Arun District Council
Arun Civic Centre
Maltravers Road
Littlehampton
West Sussex BN17 5LF
Planning & Building Control General Enquiries
Tel: (01903) 737756 Fax: (01903) 730442
Dx: 57406 Littlehampton
Minicom: 01903 732765
e-mail: planning@arun.gov.uk
website: www.arun.gov.uk/planning

Application No: K/55/20/PL
Site Address: 57 Coastal Road Kingston BN16 1SN
Description of works: Demolition & erection of 1 No. dwelling. This application is in CIL Zone 4 and is CIL Liable as new dwelling.

Thank you for your internet representation made on 22nd January 2021 which has been recorded as an objection with the comments as follows:

For ST Charles Homes LTD	
Drawing Proposed Plans&Elevations	
Project La Casa, 57 Coastal Road, West Kingston East Preston BN16 1SN	
Scale	1:100
Date	19.11.2020
Made by Arch. Grygorieva A.A.

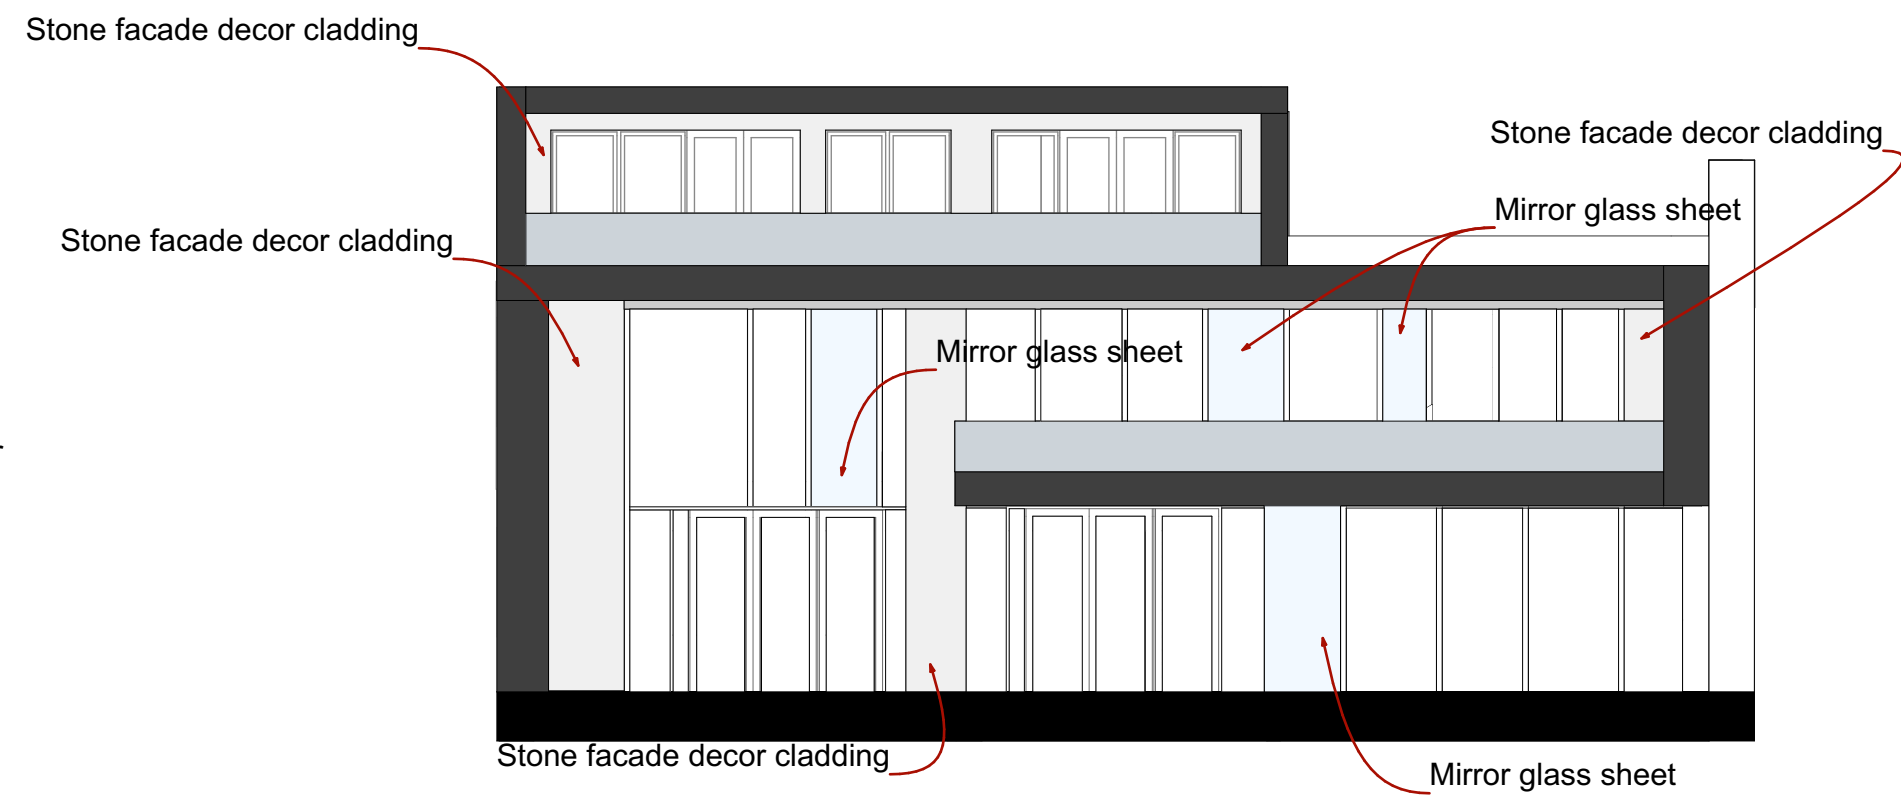
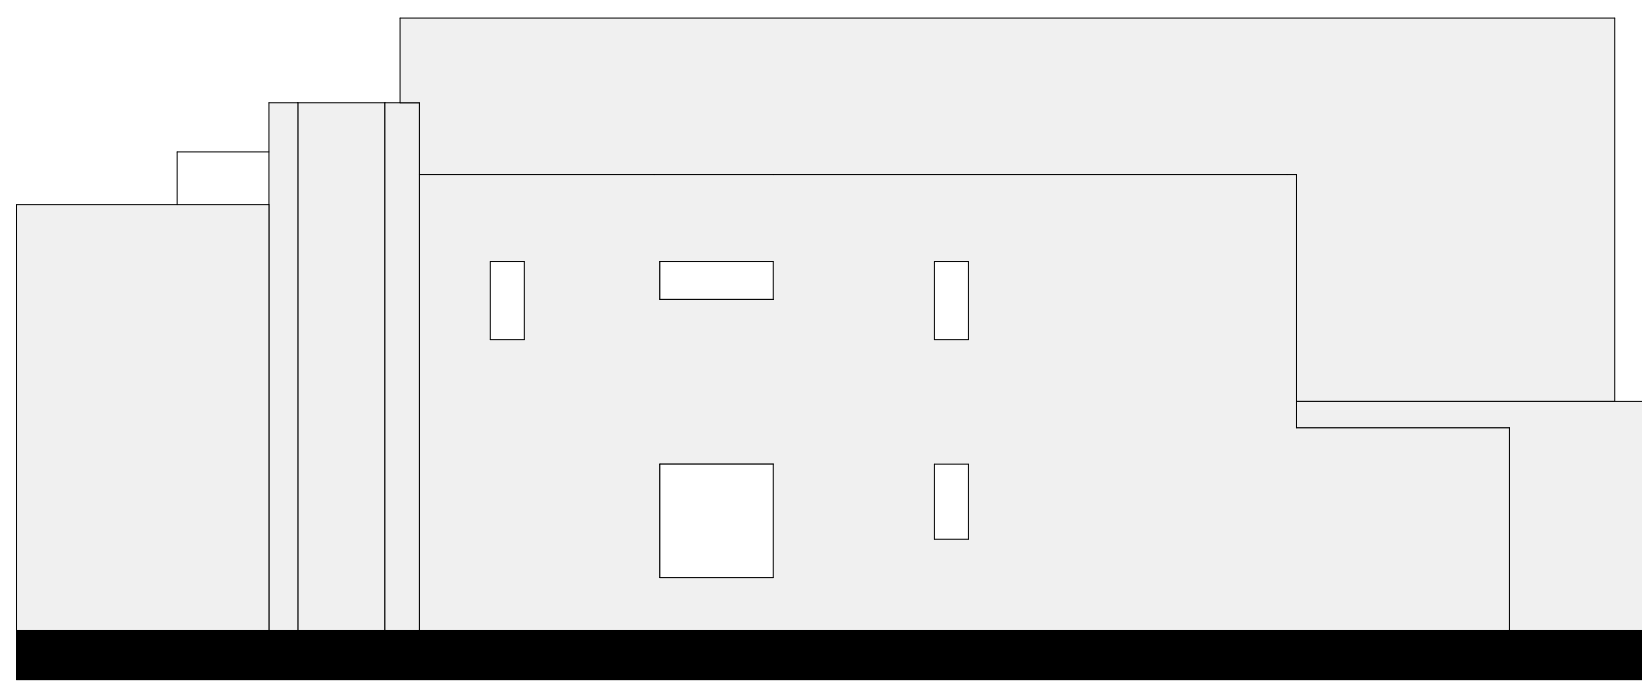
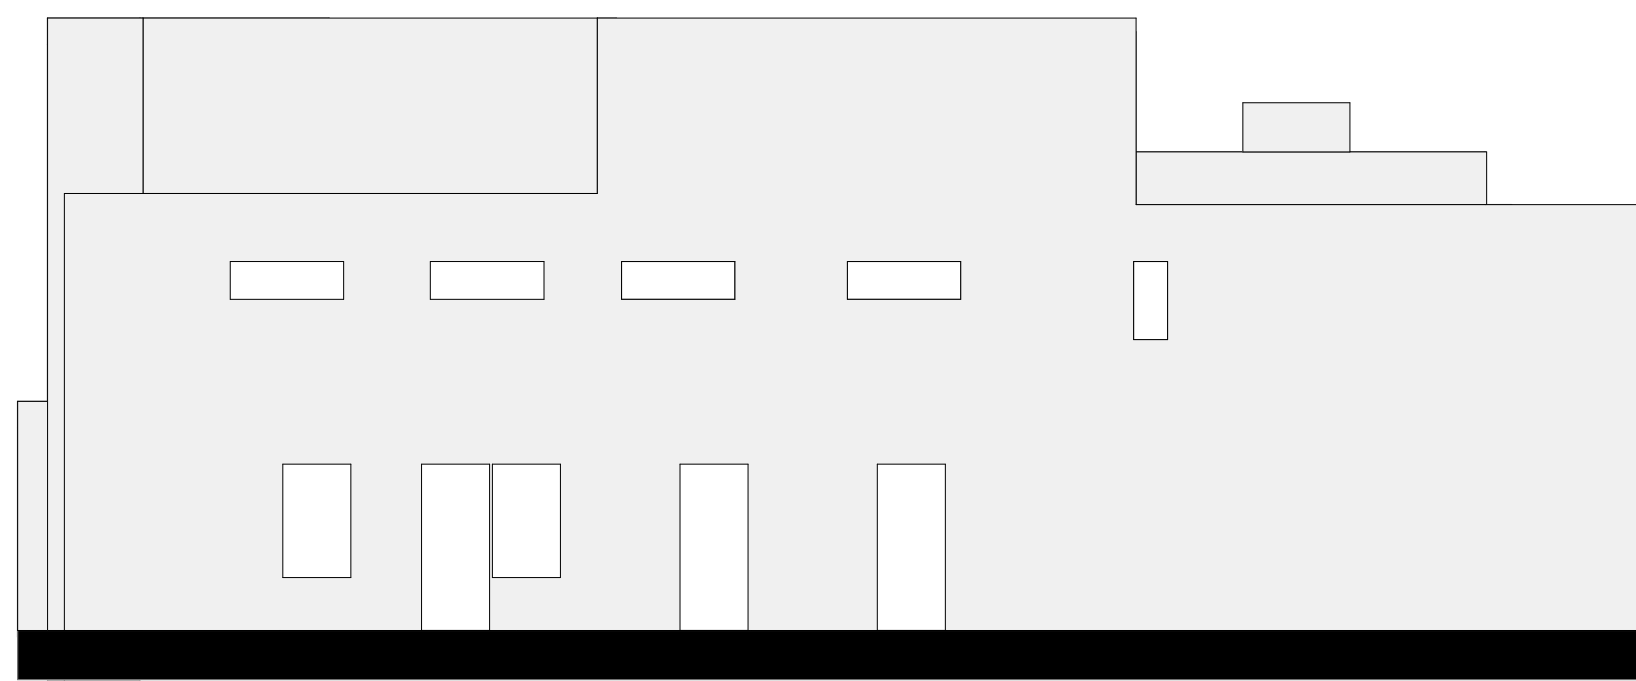
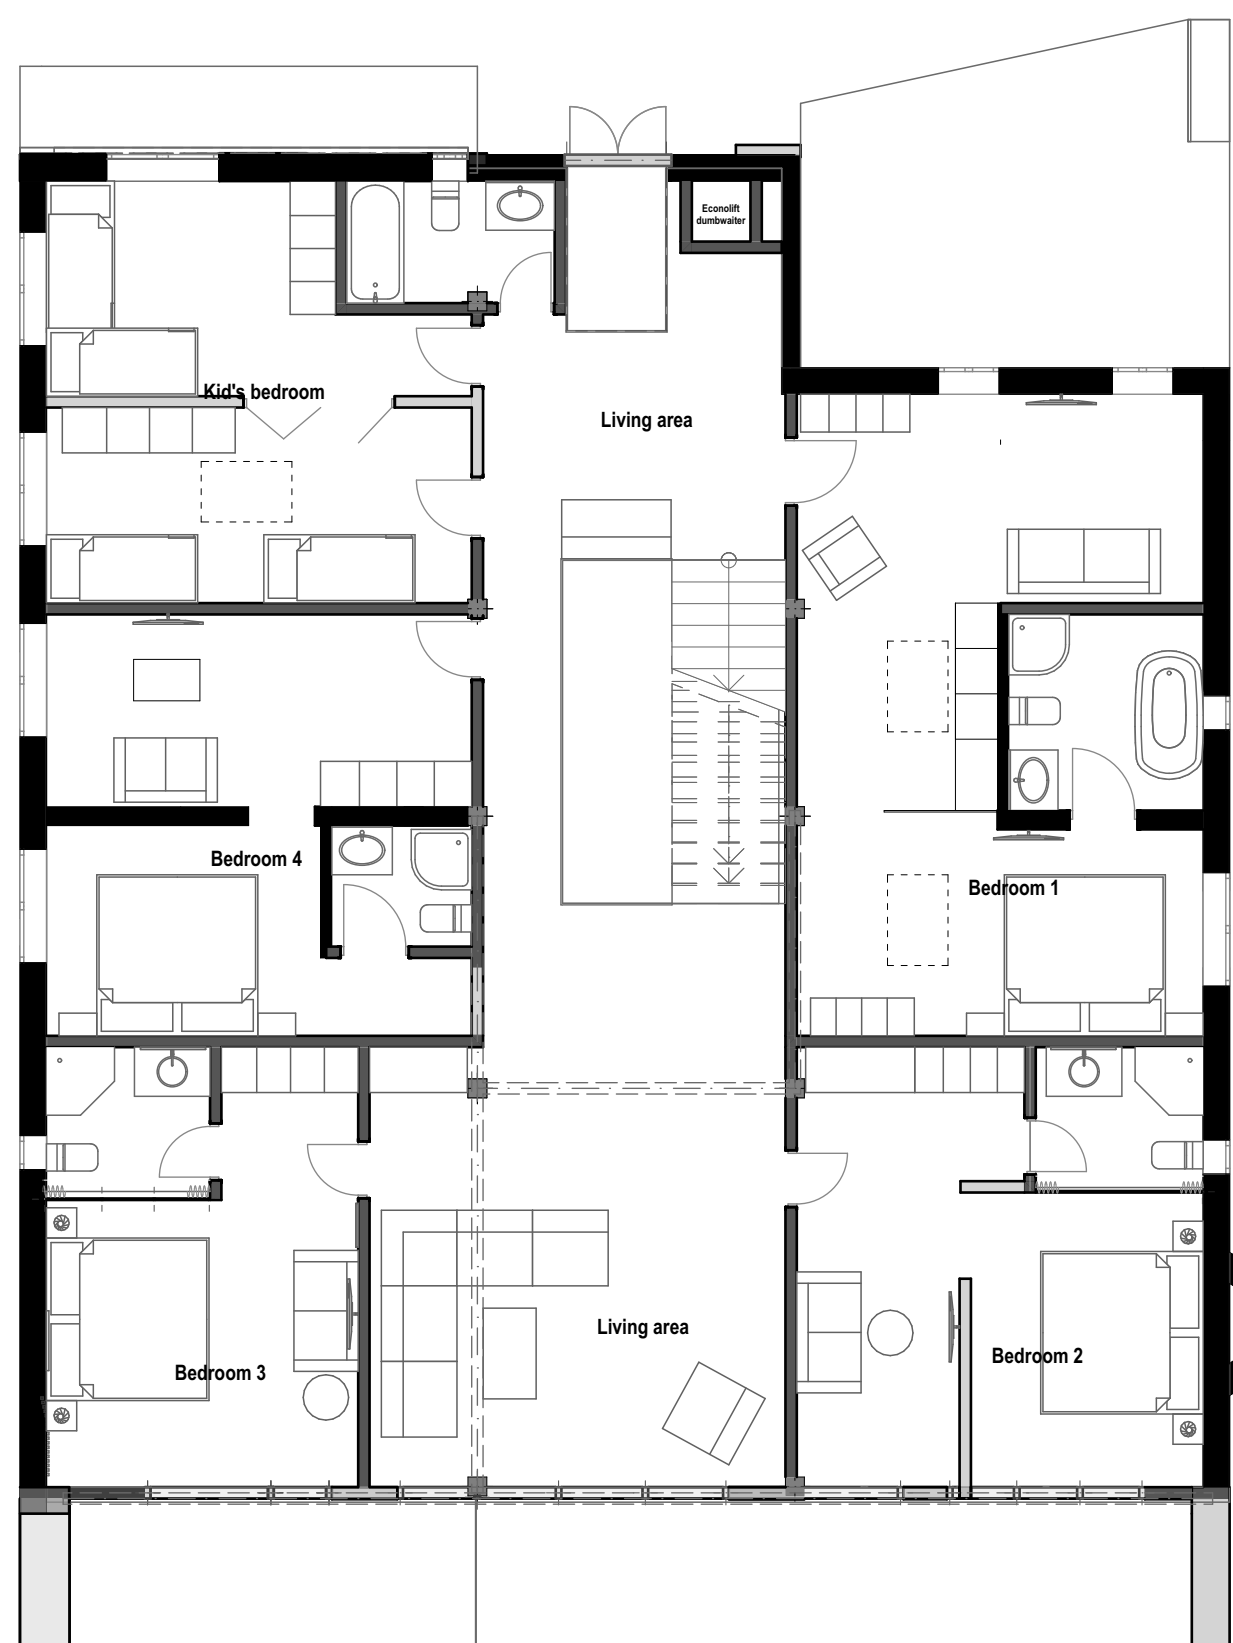
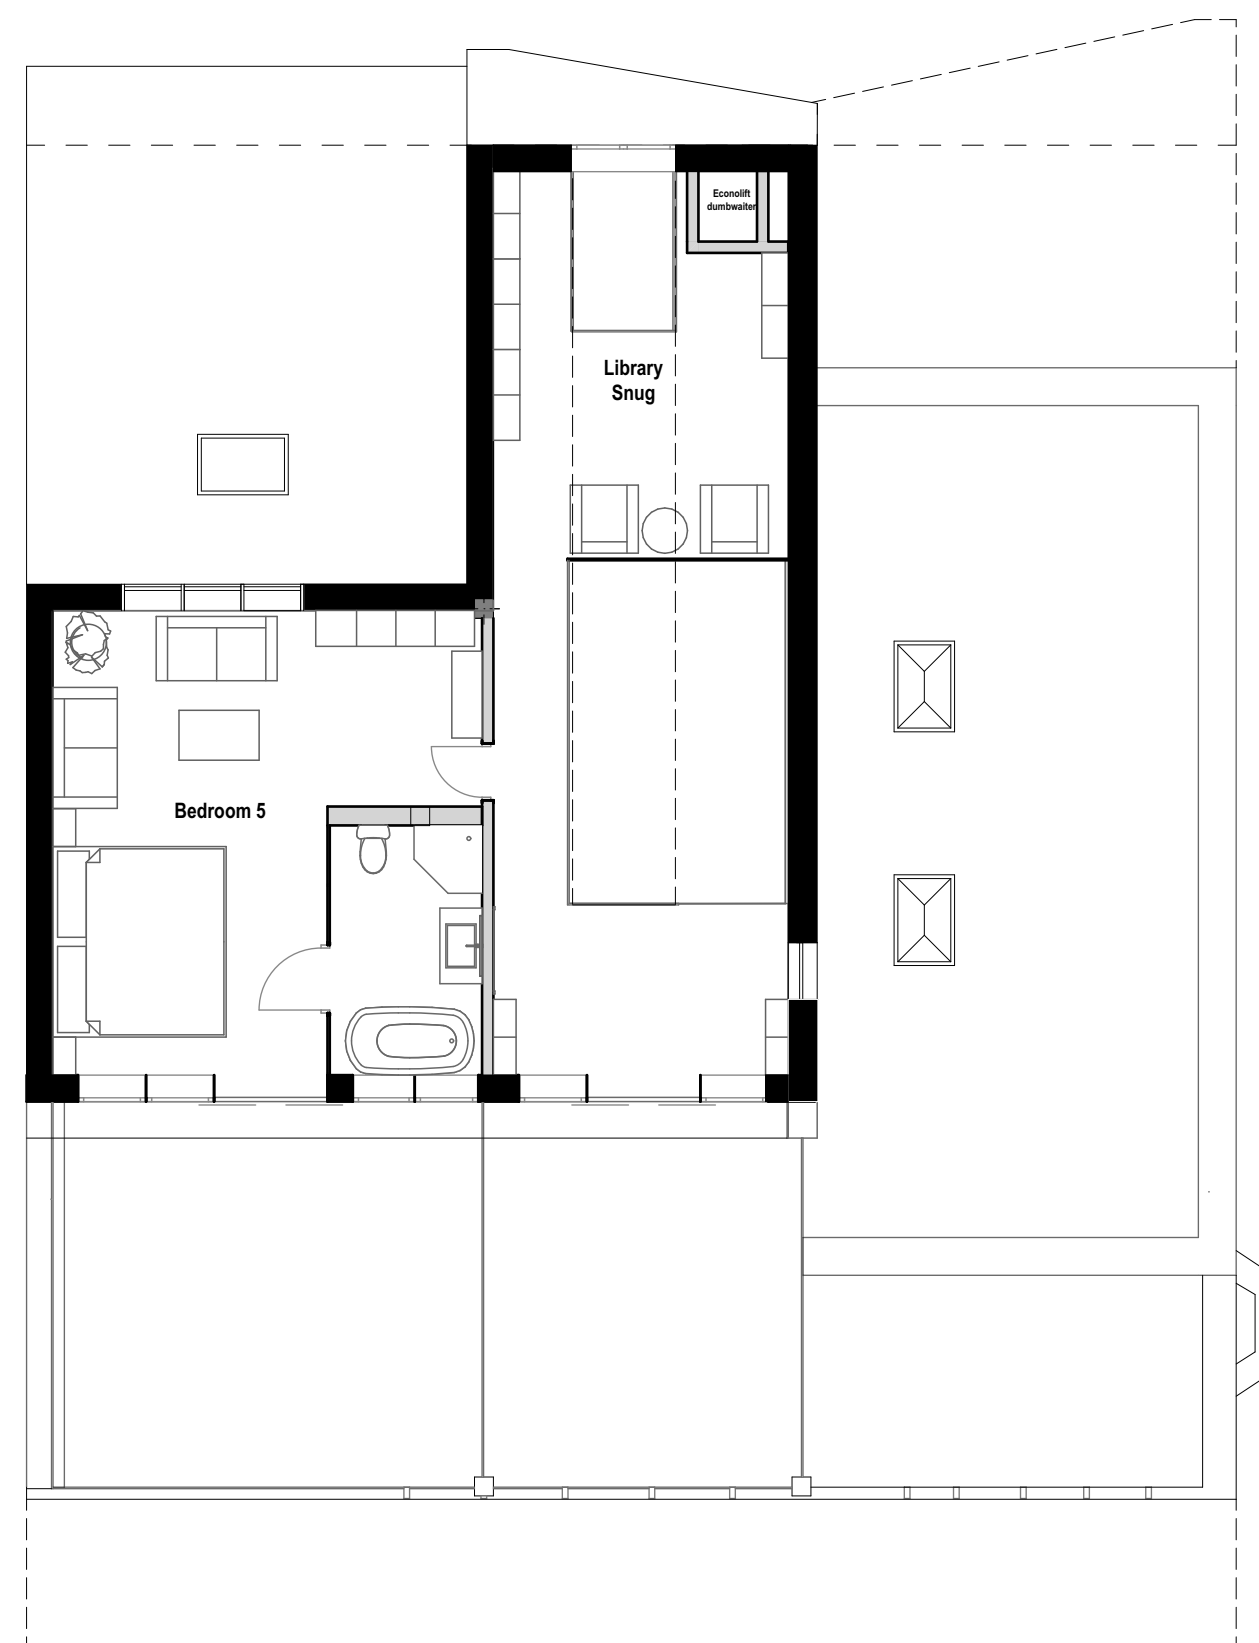
In addition, whilst the drawings do not clearly annotate these, it is understood that there are proposed to be rear terraces at both first and second floor level which is considered will introduce serious levels of overlooking and loss of privacy to the immediate neighbours at no 55 and 59.

Whilst it is recognised that contemporary design has been introduced in the area, the overall design of the proposed dwelling is one which does not complement this part of the Estate and its immediate setting. I believe it is bland and unexceptional in its appearance. Furthermore, the extensive built form by way of massing, three storey scale, excessive height and bulk as well as the wide ranging use of glazing will, in my view, result in a highly unacceptable and inappropriate form of development on this site, which will detract from the pleasant environment as well as harm adjoining residential amenities in terms of loss of sunlight, outlook and the creation of a sense of overbearing and loss of privacy, having regard to the fact that the building footprint is proposed to be extended both to the north and south in comparison with the existing dwelling which itself is already dominant and occupies an appropriate footprint.
